REQUEST

Current Zoning: N1-A (neighborhood 1-A), CG (general business)
Proposed Zoning: I-1(CD) (light industrial, conditional)

Approximately 3.55 acres bound by the east of side of Lakebrook Road, north side of Centergrove Lane, west side of Sam Wilson Road, and south side of Interstate 85.

The petition proposes to allow the development of convenience store with gas and diesel fuel pumps along with accessory and incidental uses associated with the principal use. The site is currently undeveloped.

FILE LOCATION: \\s:\Drawings\Projects\QuikTrip\1001 (Charlotte, NC)\81-1001 Civil.dwg TAB NAME: Rezoning Plan USER: EdEnser SAVED: 1/19/2024 11:43 AM PLOTTED: 1/19/2024 3:13 PM

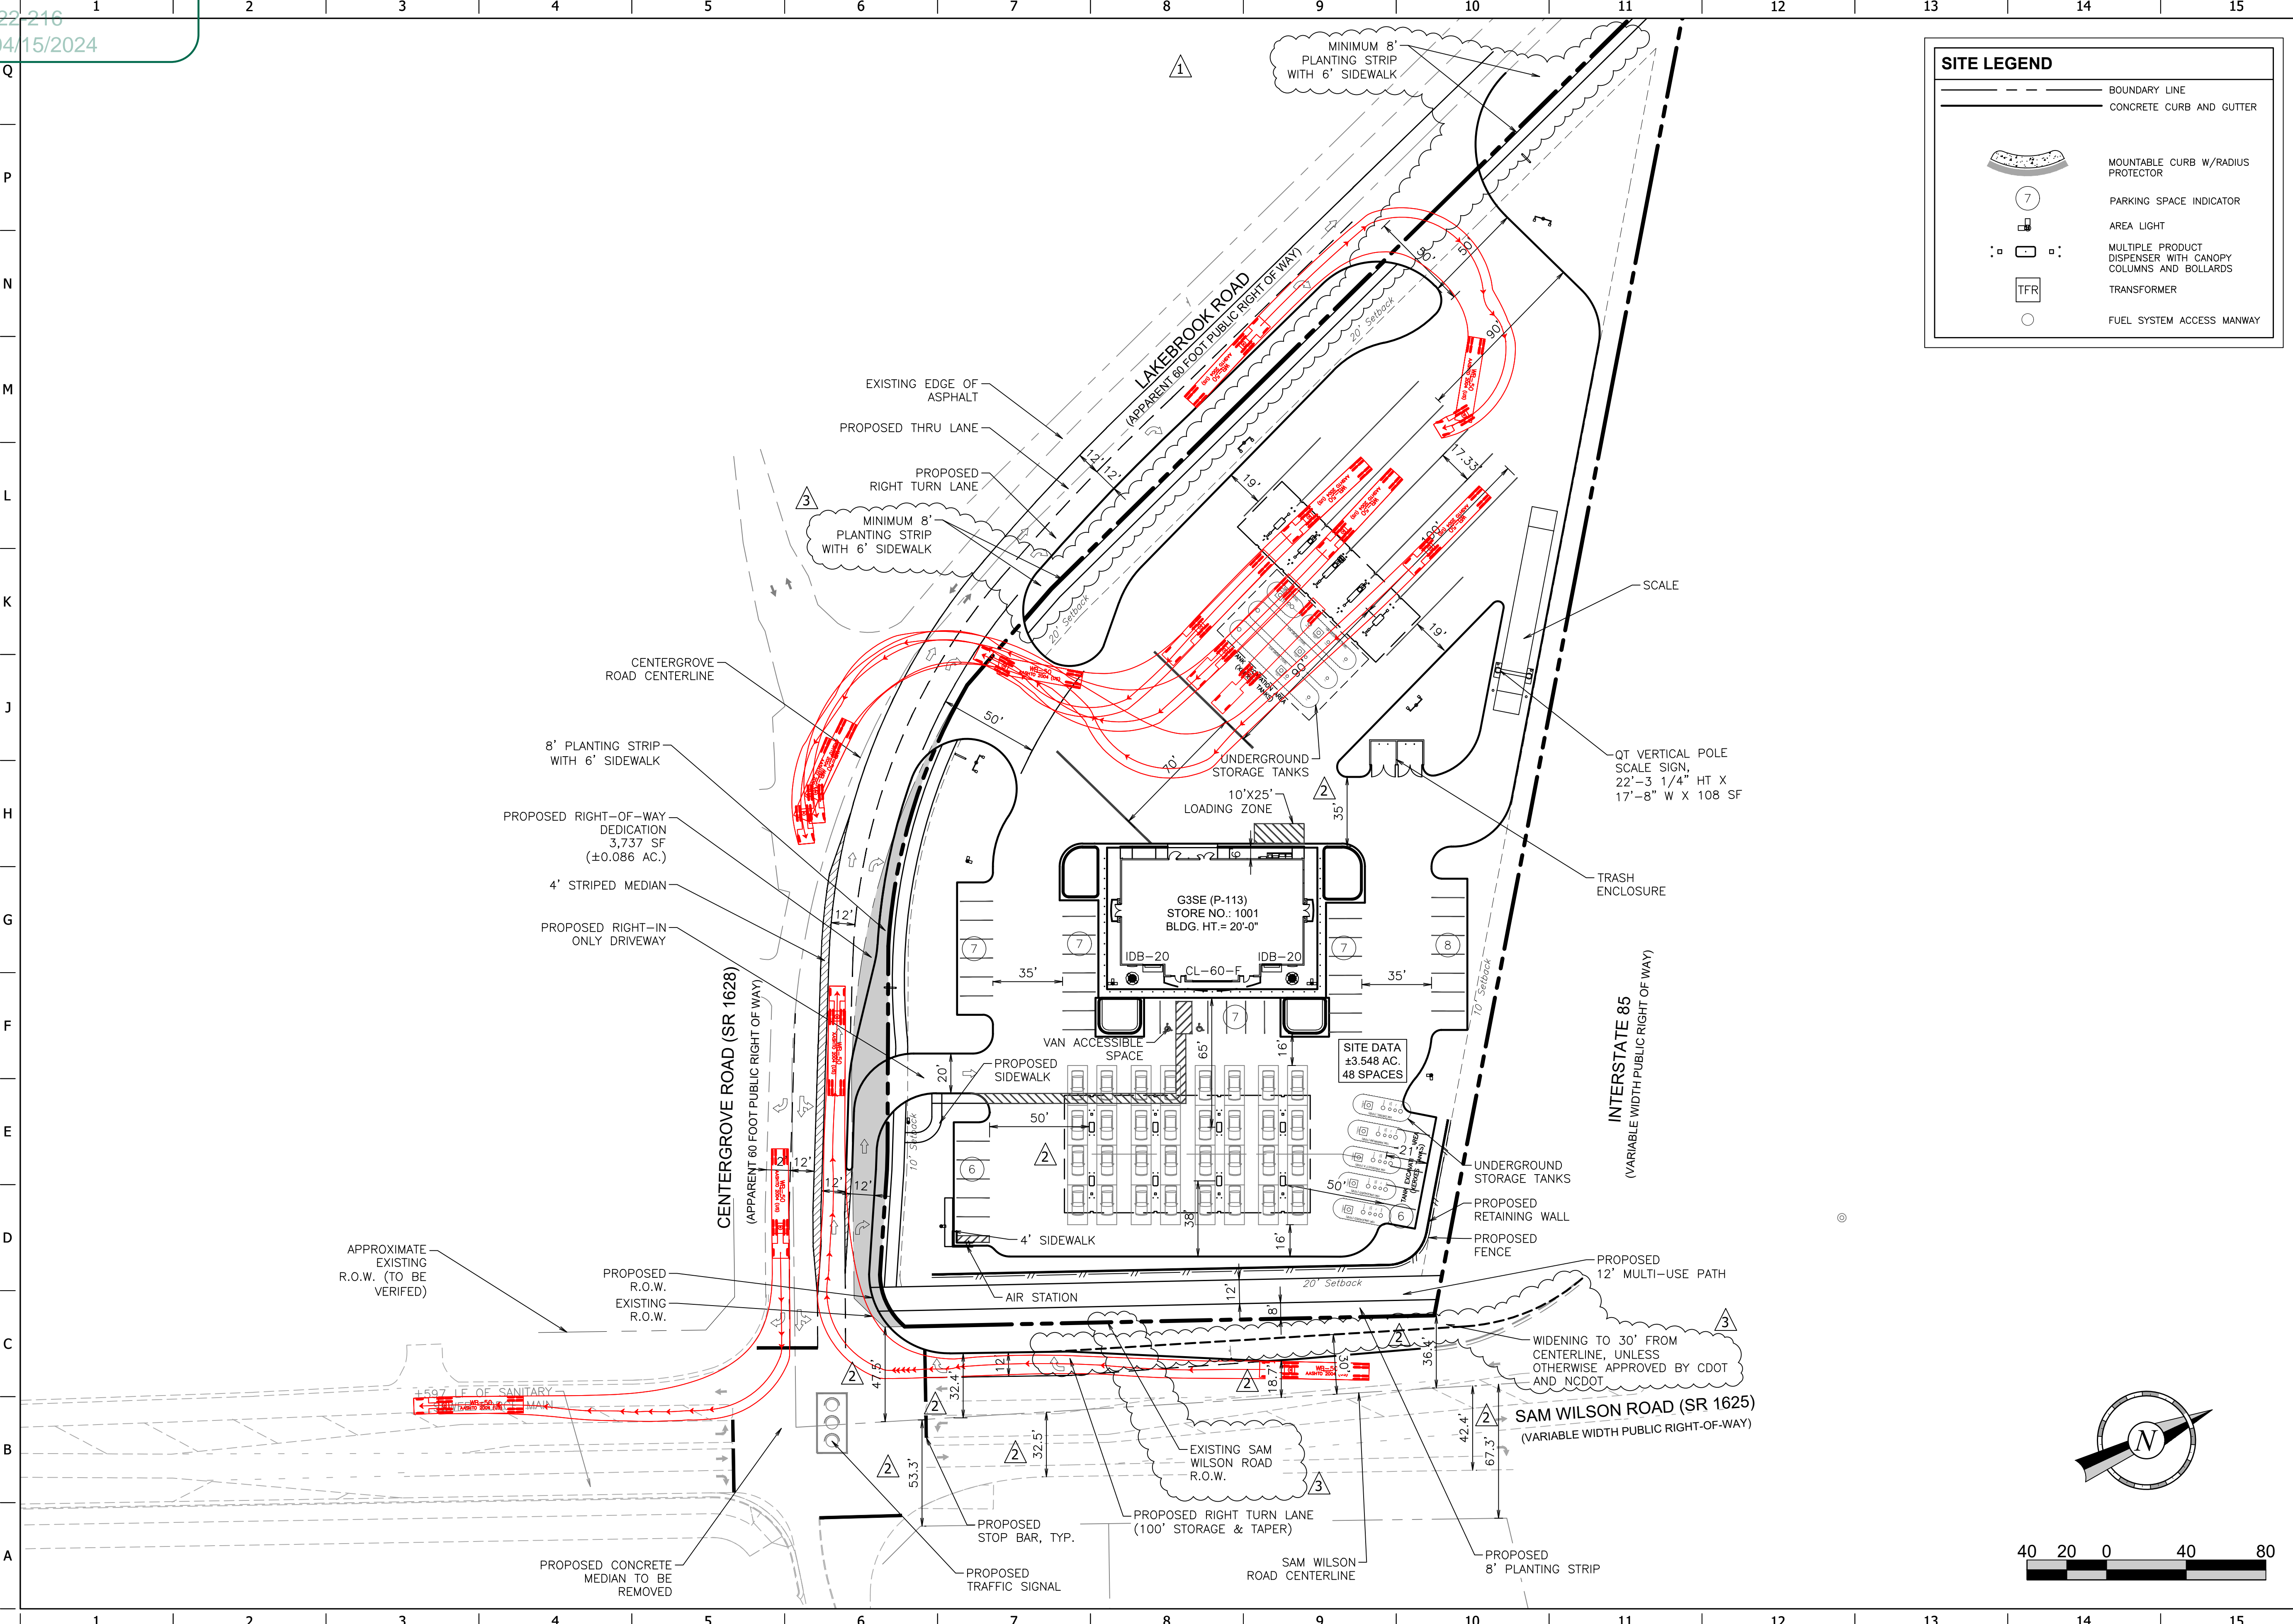
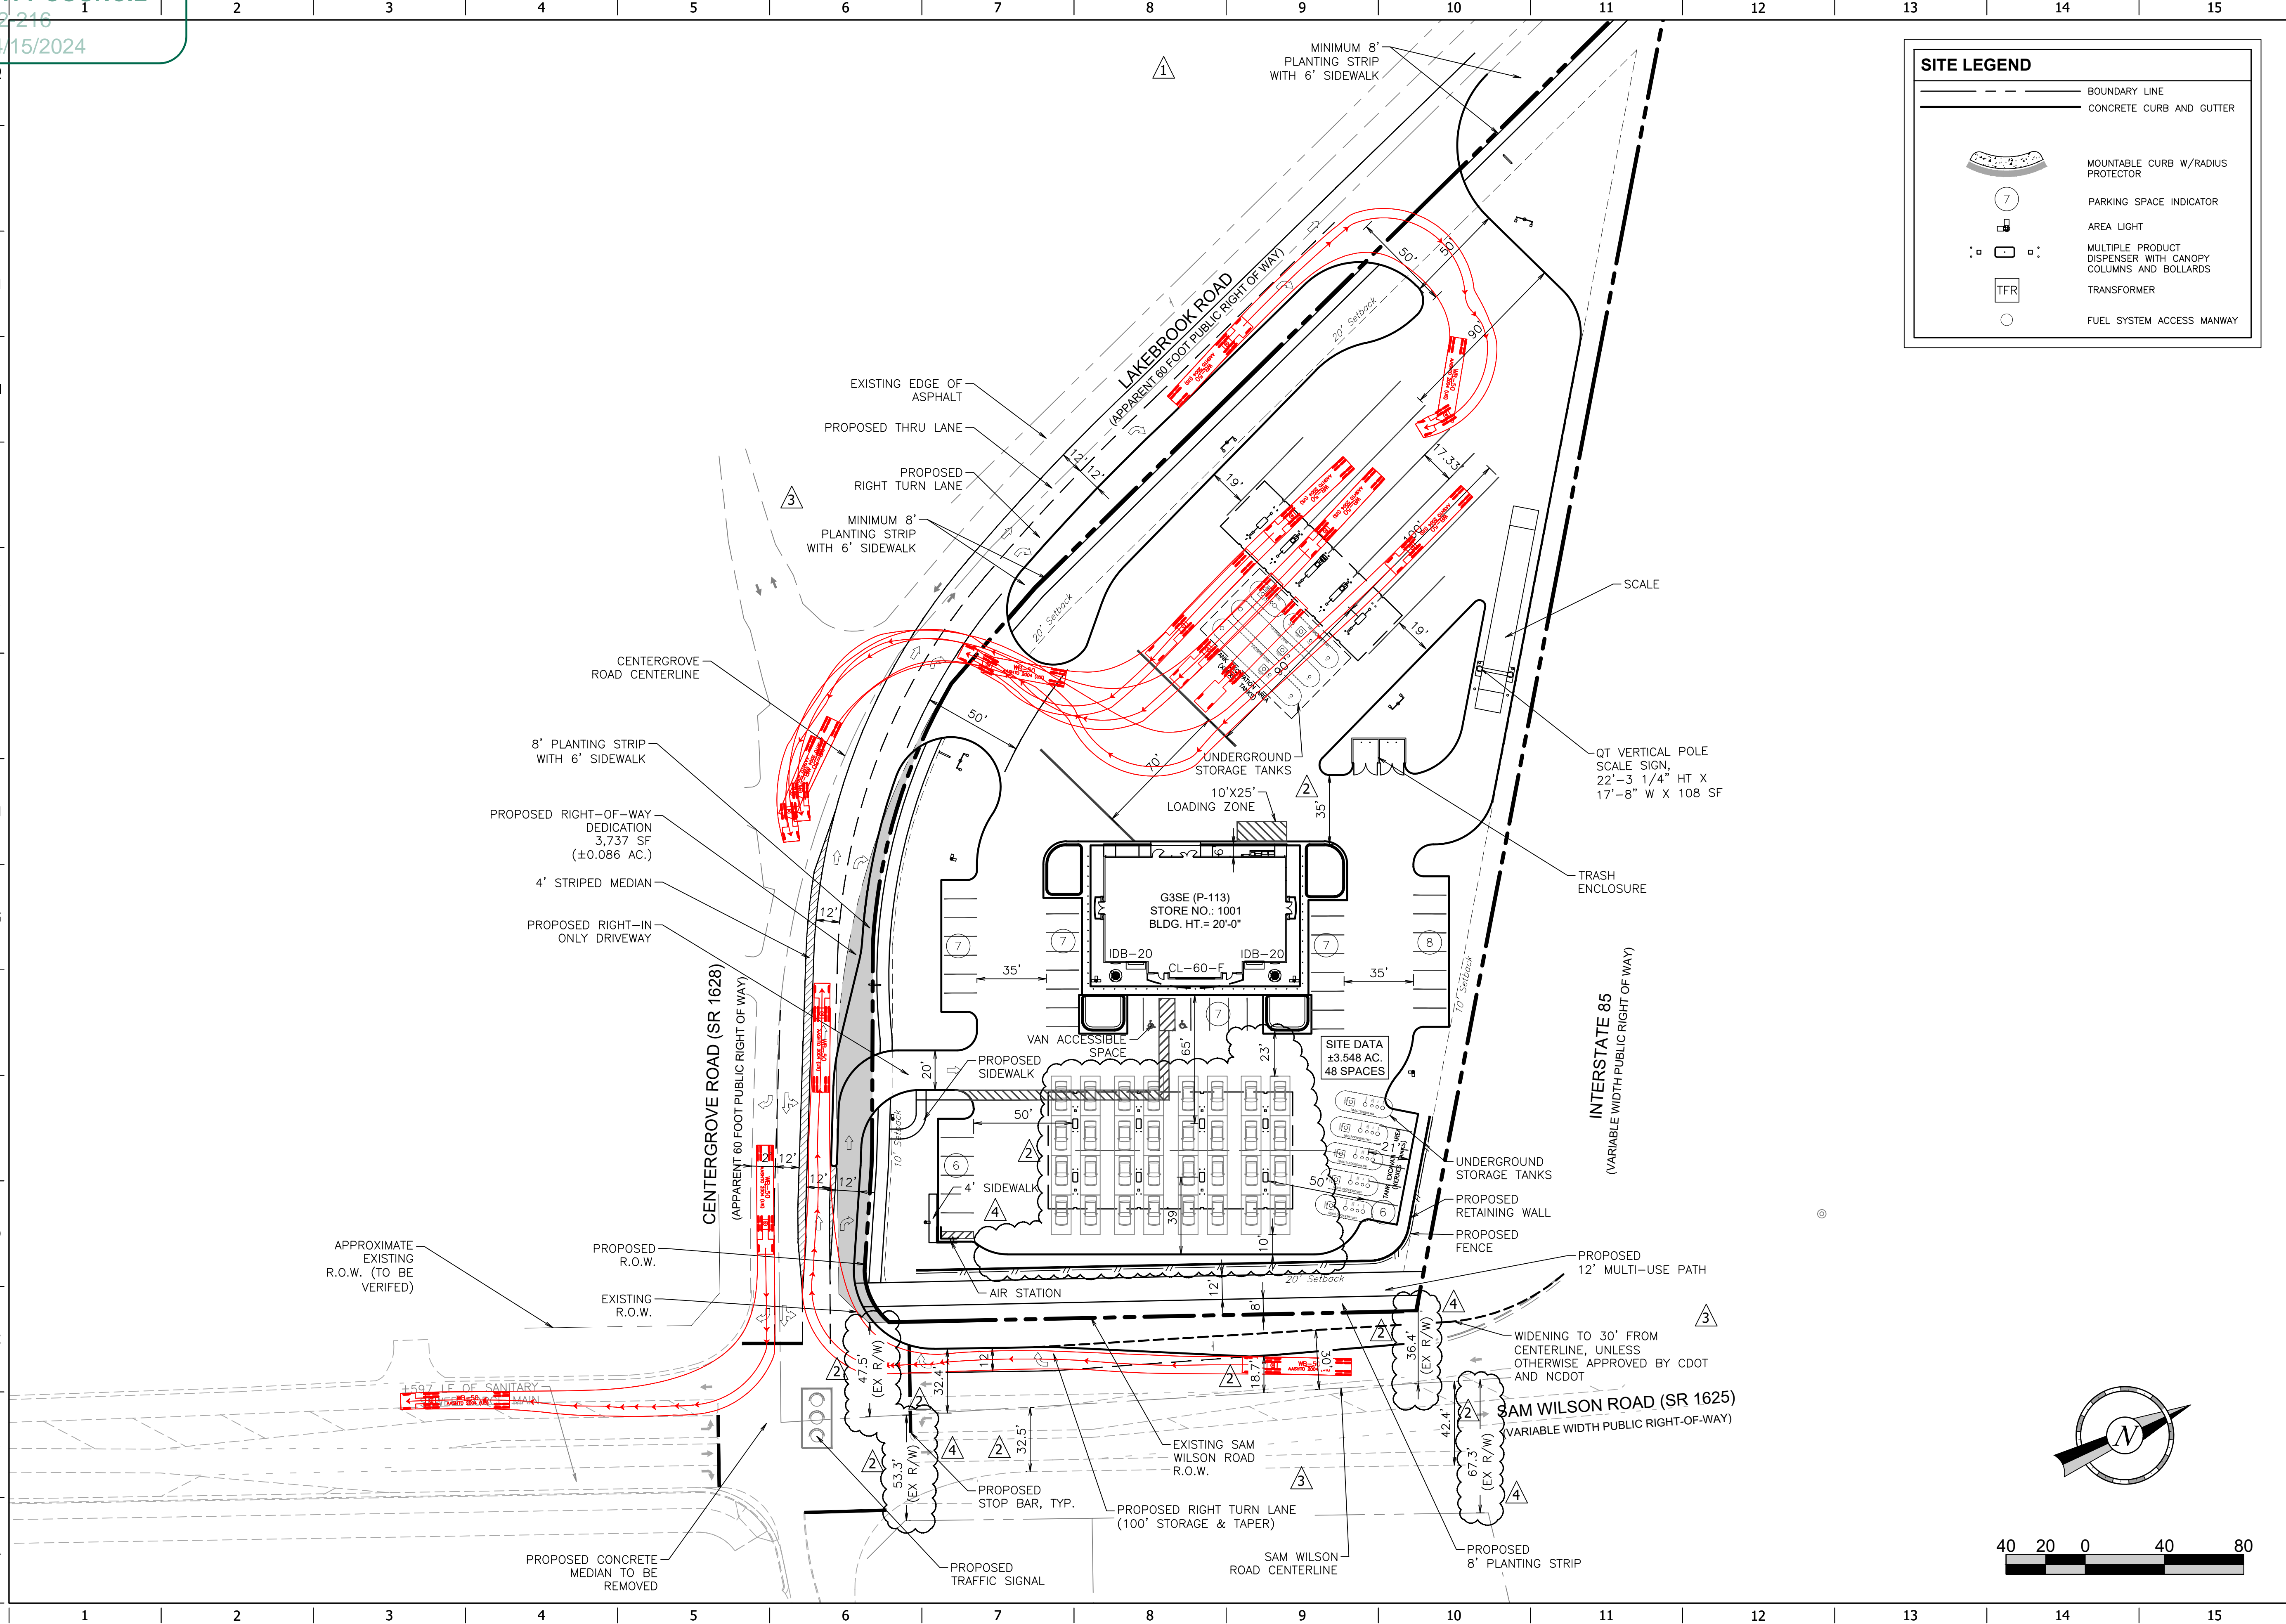
- ~~1. Location of curb and gutter to be moved to 30 feet from roadway centerline to accommodate the Charlotte Streets Map with a roadway typical section of a 4+ avenue with a 12-foot multi-use path. Label and dimension curb and gutter 30 feet from roadway centerline on Sam Wilson. **ADDRESSED**~~

- ~~2. Revise site plan and conditional note(s) to commit to dedicate 35 feet of right-of-way from the road centerline on Sam Wilson Road. The site plan shall label and dimension the right-of-way from the road centerline. Label and dimension right-of-way from roadway centerline on Sam Wilson. **ADDRESSED**~~

- ~~3. Revise site plan to clearly show and label where existing right of way is and proposed right of way. **ADDRESSED**~~
- ~~4. Revise site plan and conditional note(s) to construct 8-foot planting strips and 6-foot sidewalks on Centergrove Lane and Lakebrook Road and a 12-foot multi-use path on Sam Wilson Road. The site plan shall label and dimension both items from the back of curb and gutter or edge of pavement. Add conditional note The entire facility must be outside of the right of way and within a public access easement. Add conditional note committing to construction and maintenance of the 6-foot sidewalk on Centergrove Lane and the 12-foot multi-use path on Sam Wilson Road. Add conditional committing to maintenance of 6-foot sidewalk on Centergrove Lane. **ADDRESSED**~~
